ENG-SF20015-R4-CDs.pdf Markup Summary

STRM_19 PROFILE STA 0+00.00 TO 13+29.82 PRIVATE (SRMD)

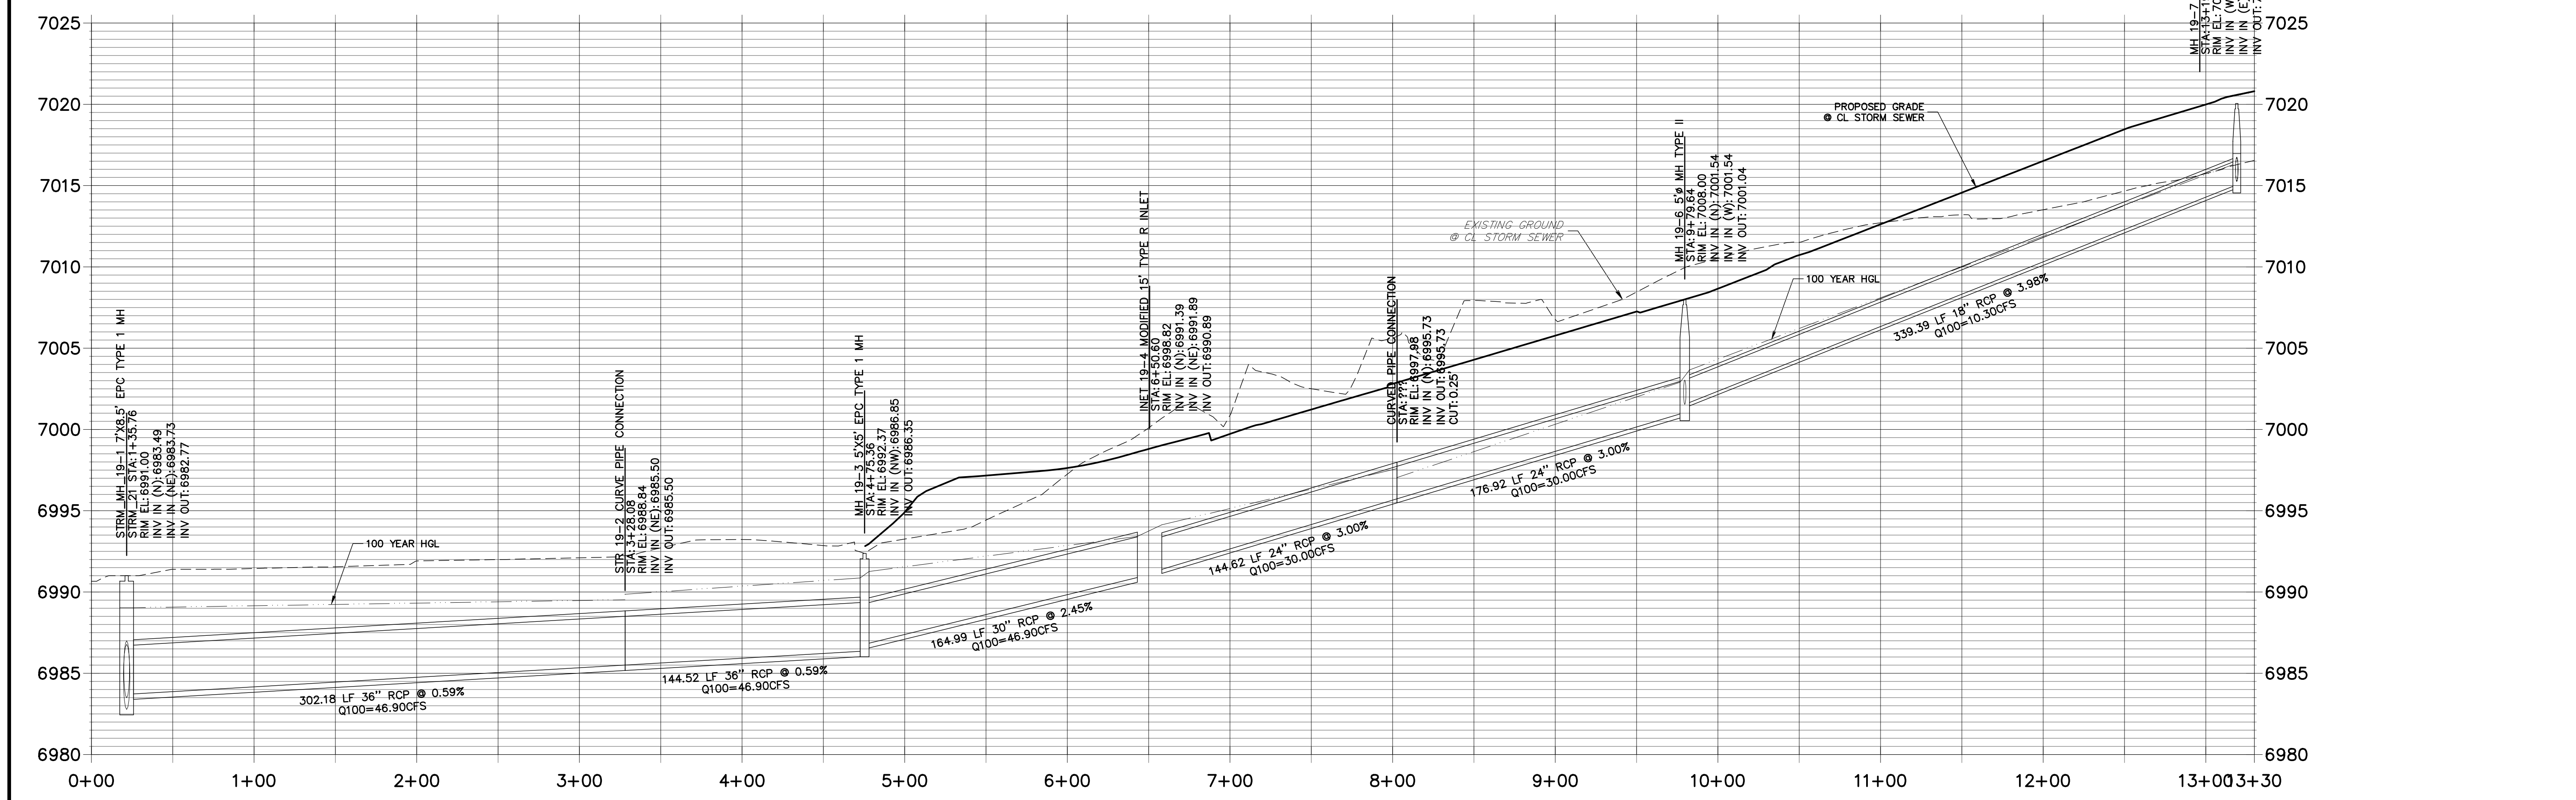
Delete (SRMD)

12 PROFILE TO 13+29.82 (SRMD)

**STRM_23 PROFILE
STA 13+00.00 TO 26+00.00
PRIVATE (SRMD)**

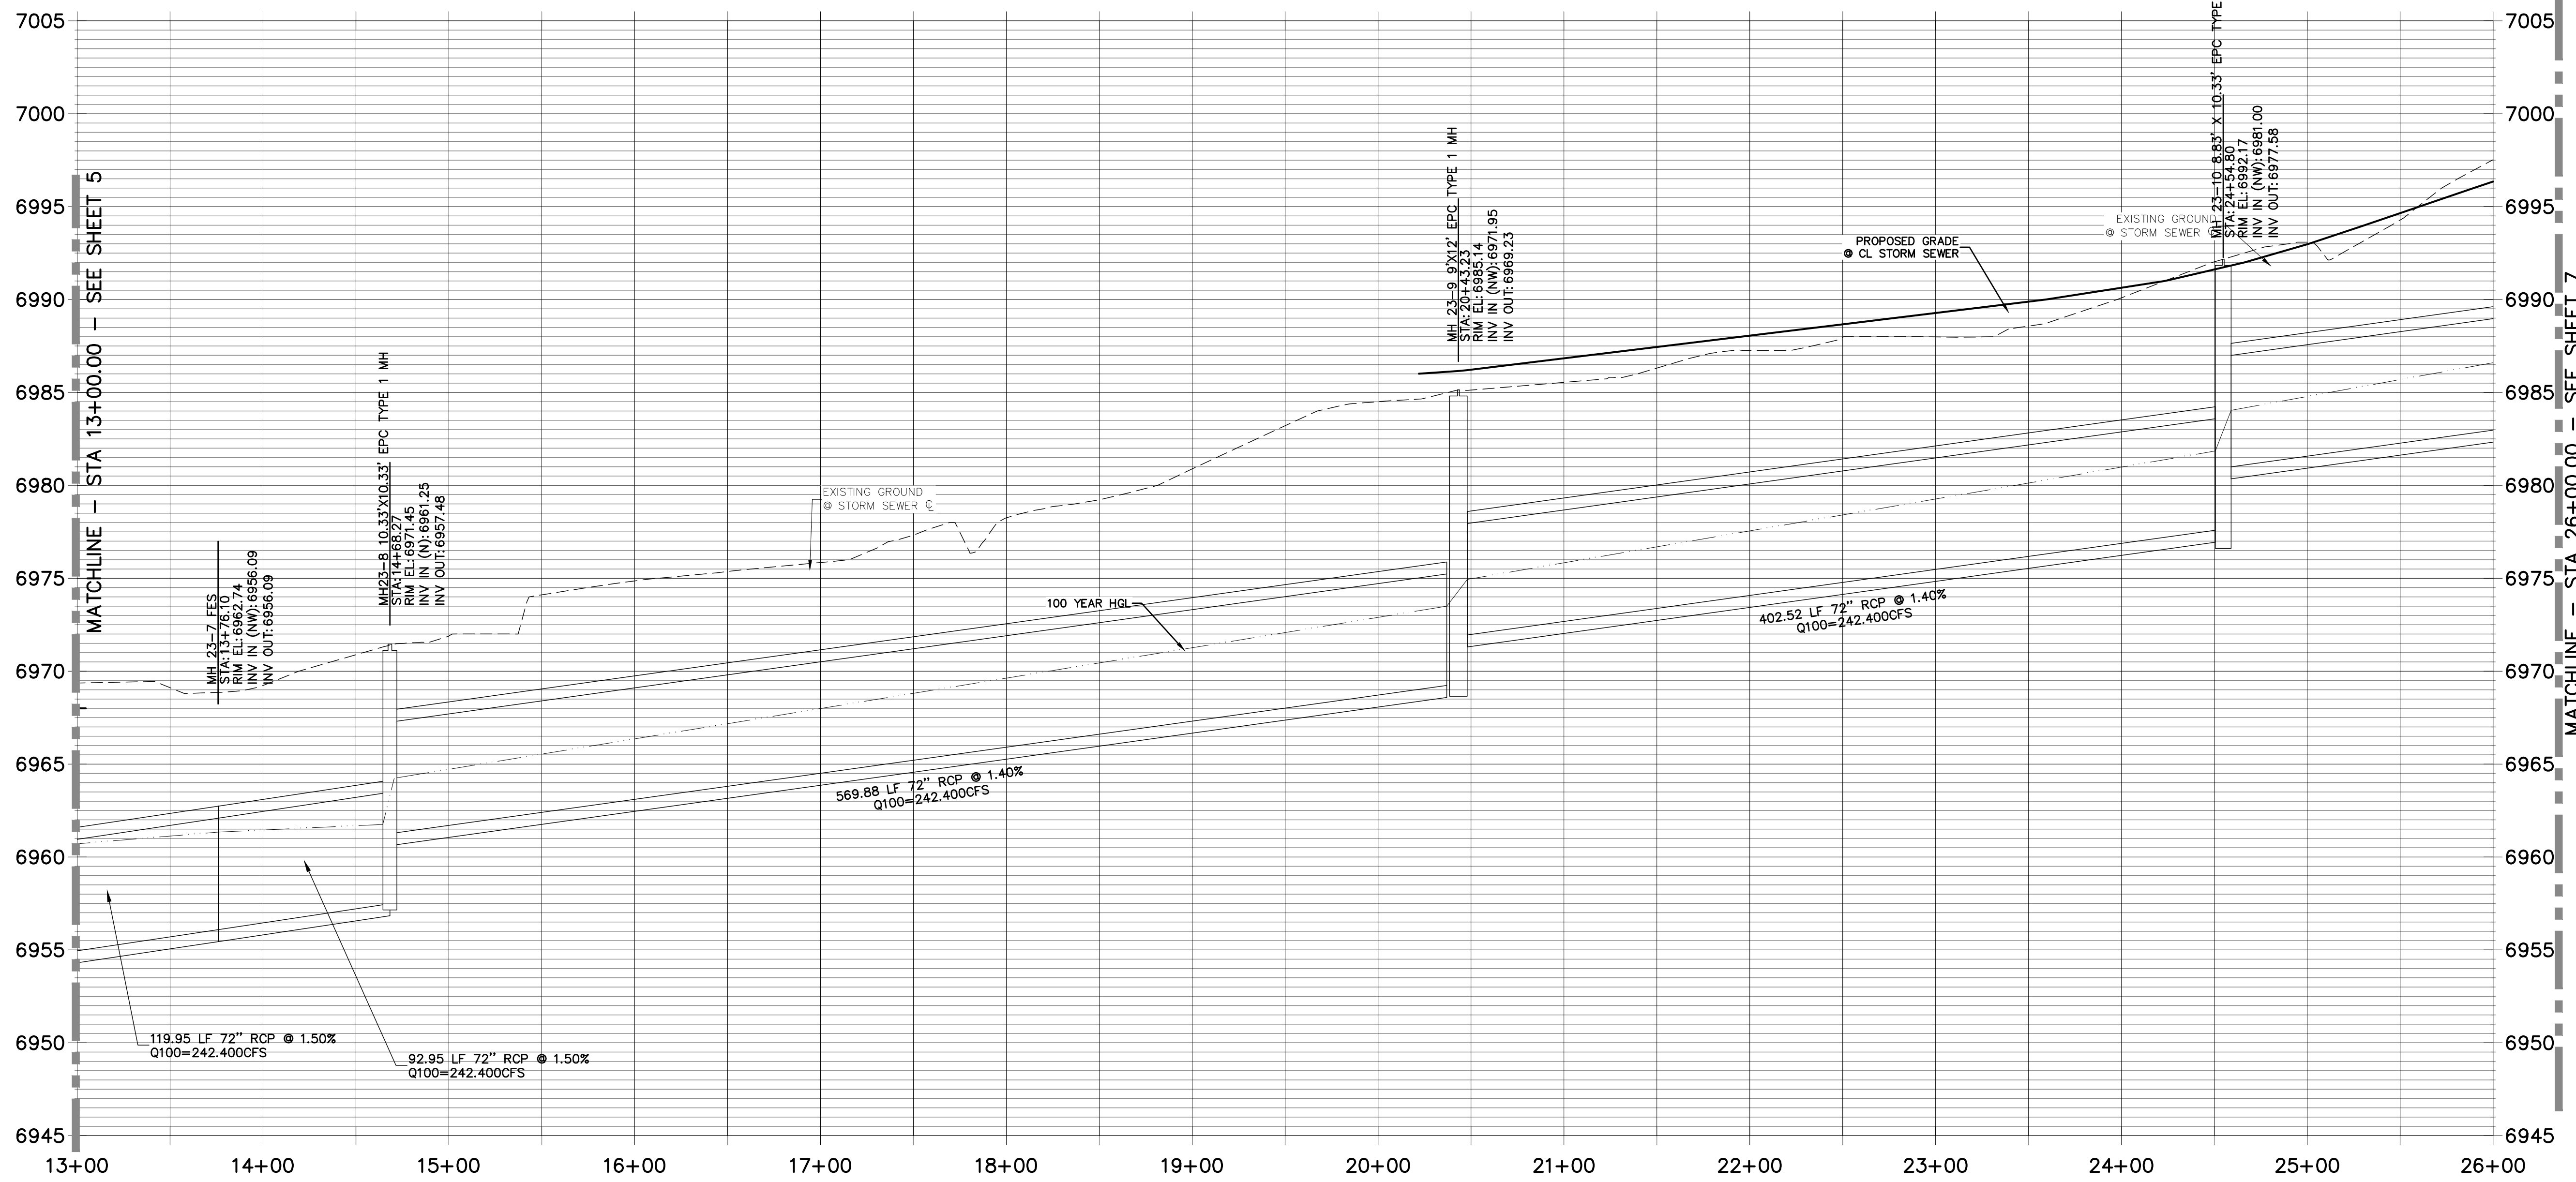
22 PROFILE
00 TO 3+50.00
IC (SRMD)
